Please ask for: Ms Iqraa Malik
Email: iqraa.malik@terraquest.co.uk
Telephone: 0121 234 1390
Our Ref: Y/63/22/HH
Your Ref:
Date: 19th May 2022

Application for Planning Permission for Works or Extension to a Dwelling

Development: Erection of single storey rear conservatory.
Location: 53b Charles Square Cinders Lane Yapton BN18 0XJ

SITE PLAN

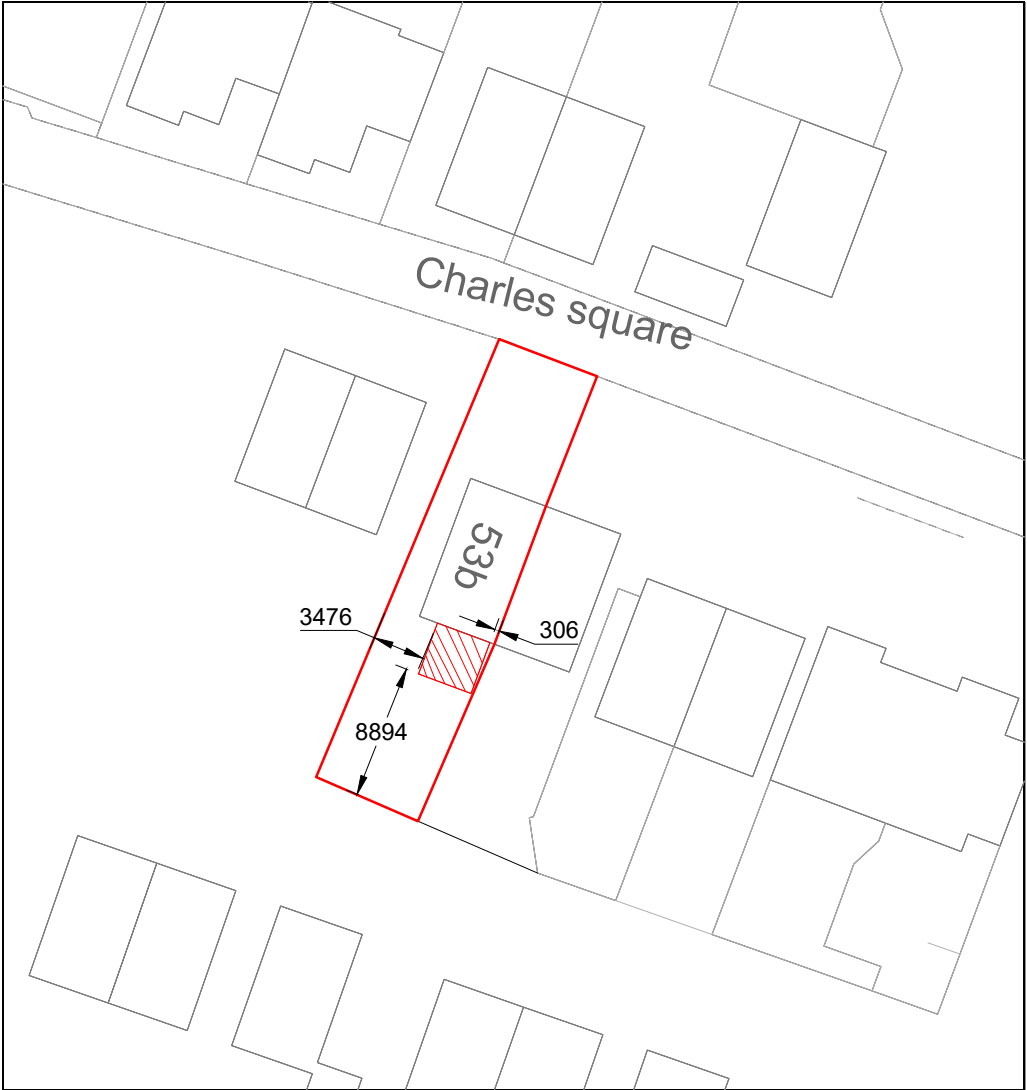
Block Plan

You are required to have dimensions from the proposed extension(s) to all site boundaries. Please amend.

Proposed rear elevation

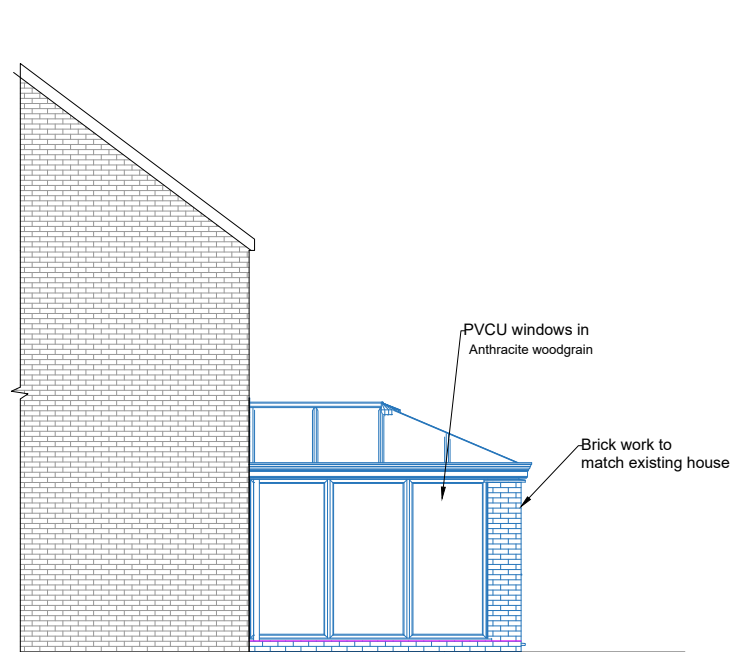
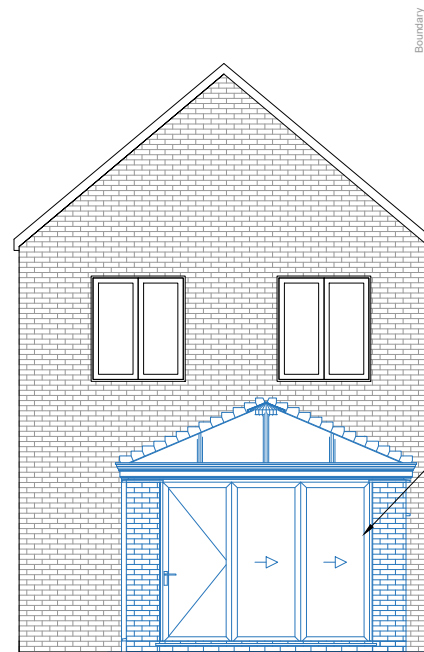
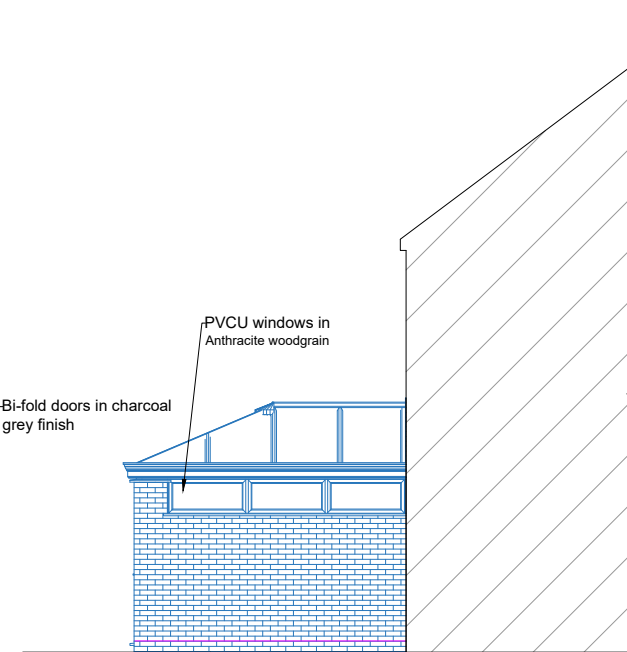
Elevations

The rear elevations submitted are labelled as front. Please amend.
